**Thames Tideway Tunnel**  
Thames Water Utilities Limited

## Thames Water's Response to Local Impact Report from Royal Borough of Kensington and Chelsea

Doc Ref: **APP30.06**

Folder **150**  
2 December 2013

**Location**  
**Cremorne Wharf Depot**  
 Royal Borough of Kensington and Chelsea

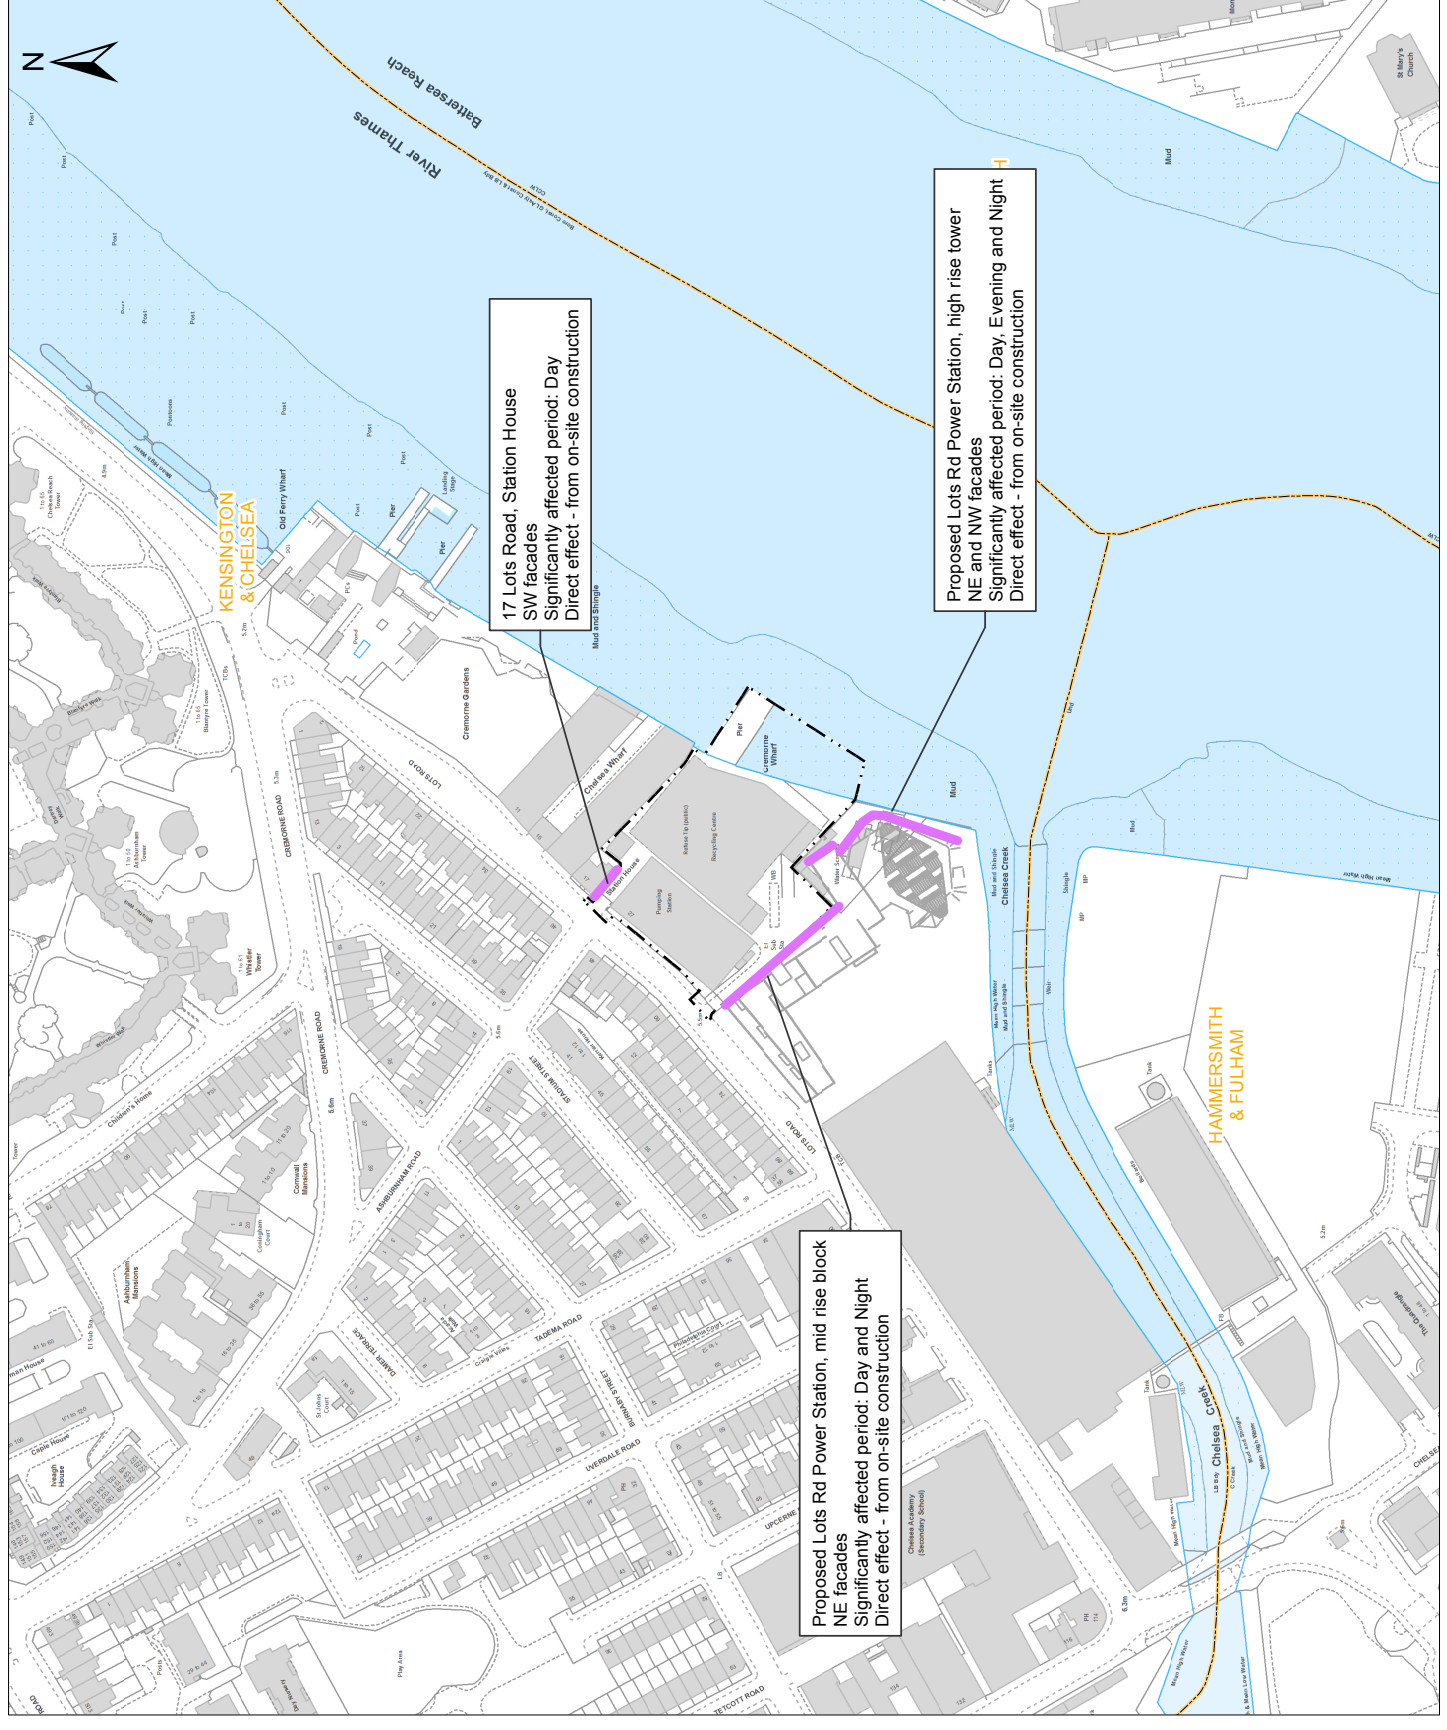
Ref	LIR para. ref	Royal Borough of Kensington and Chelsea comment	Our response
<b>8.</b>	<b>Heritage</b>		
8.1.	2.2.11	<i>“The site parameter plans for approval allow for positioning of new 6.0m ventilation columns within and immediately adjacent to the pumping station. The height of column is considered excessive and the possible location harmful to the setting of the listed building.”</i>	The arrow on plan DCO-PP-11X-CREWD-130005 points to the boundary of the zone within which the columns could be located. As stated in design principle CREWD04, we would seek to locate the column close to the river. RBKC has requested us to strengthen the design principle and this is under discussion.
<b>9.</b>	<b>Transport</b>
